**From:** Cynthia Dugan <cdugan@thehills.nsw.gov.au>  
**Sent:** Thursday, 4 March 2021 4:10 PM  
**To:** Candice Pon  
**Subject:** Expansion of the Museum Discovery Centre (SSD-10472)

I refer to your new request for advice regarding the Expansion of the Museum Discovery Centre (SSD-10472). The following comments are made:

Figure 15 Proposed relocation of TAFE parking spaces

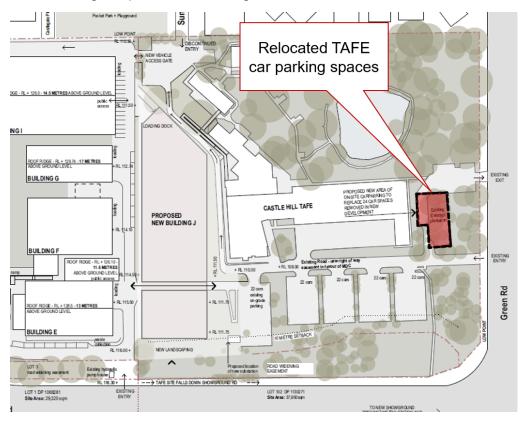
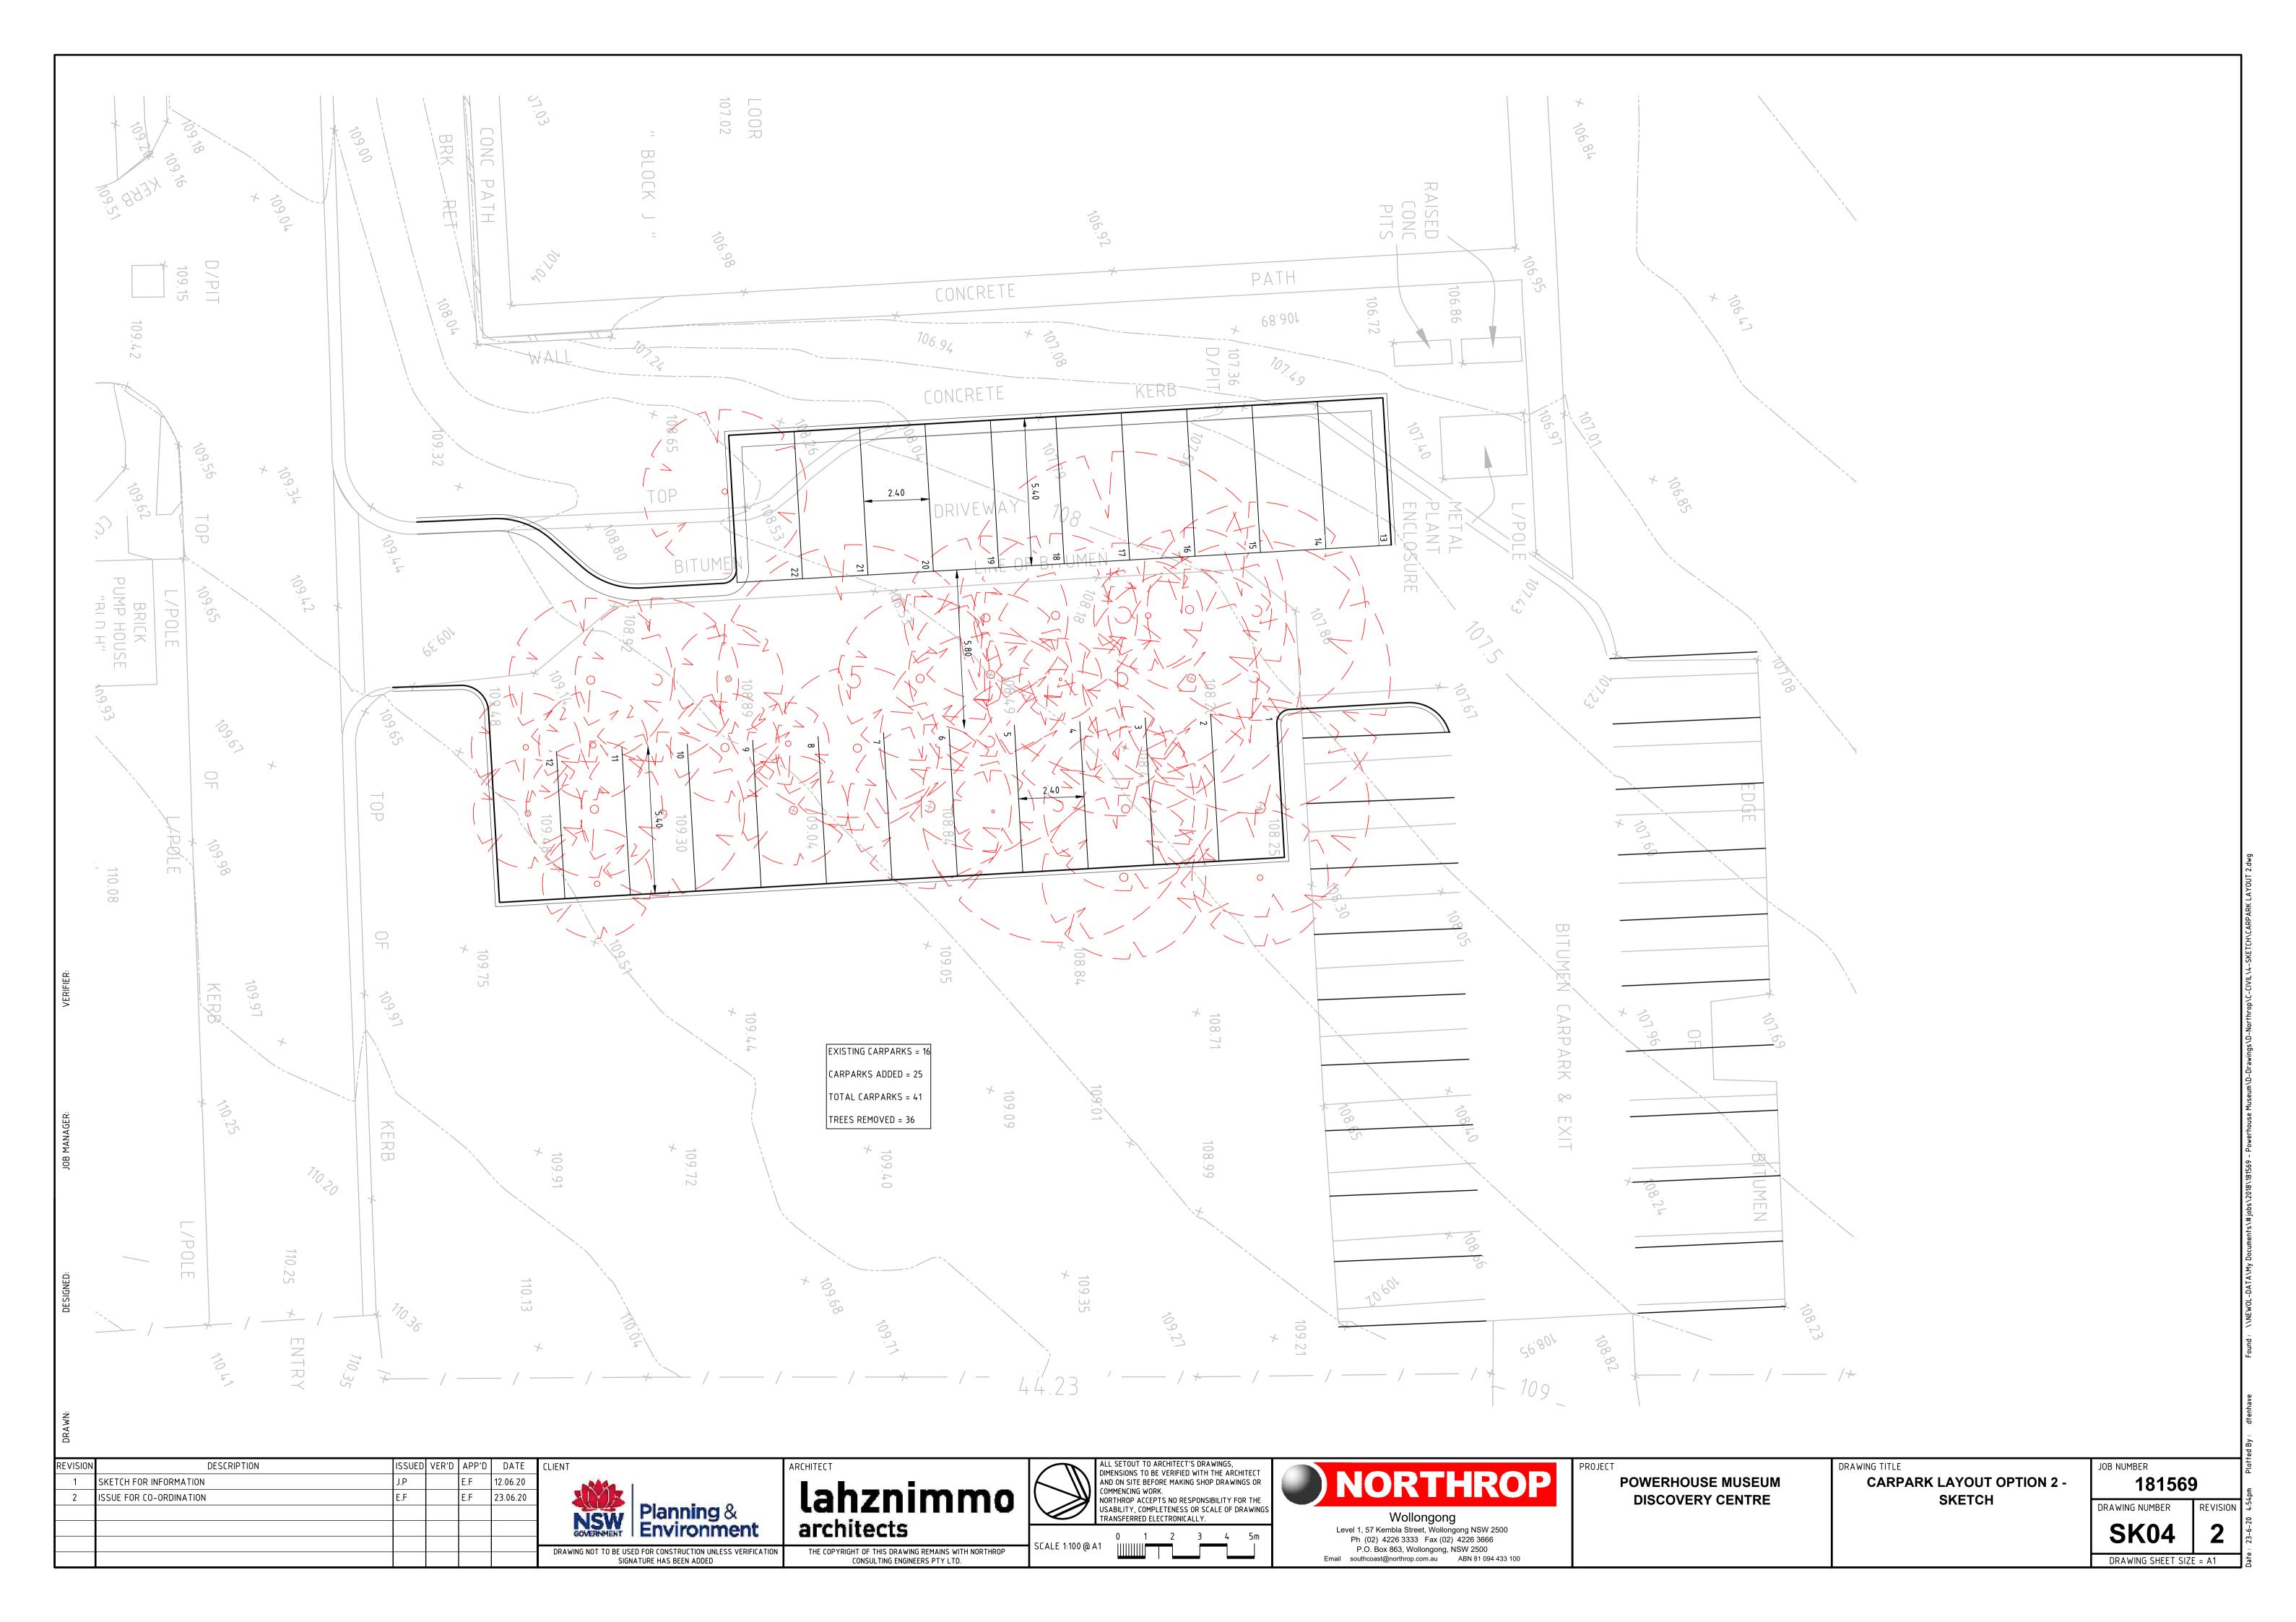
The two sites exist separate to one another. I note the proposal removes 22 formal TAFE spaces and 39 informal TAFE spaces (according to the plans approved with DA 1674/2007/HA for the TAFE expansion) to make way for the museum expansion and replaces them with 24 spaces elsewhere on the TAFE site. The consent authority should ensure that the overall parking numbers provided are sufficient for both approved uses on each site. Ordinarily, if Council were the consent authority, formalisation of this joint access/ parking arrangement would be required through the creation of cross easements on title. The consent authority should consider this as part of the proposed subdivision/ boundary adjustment.
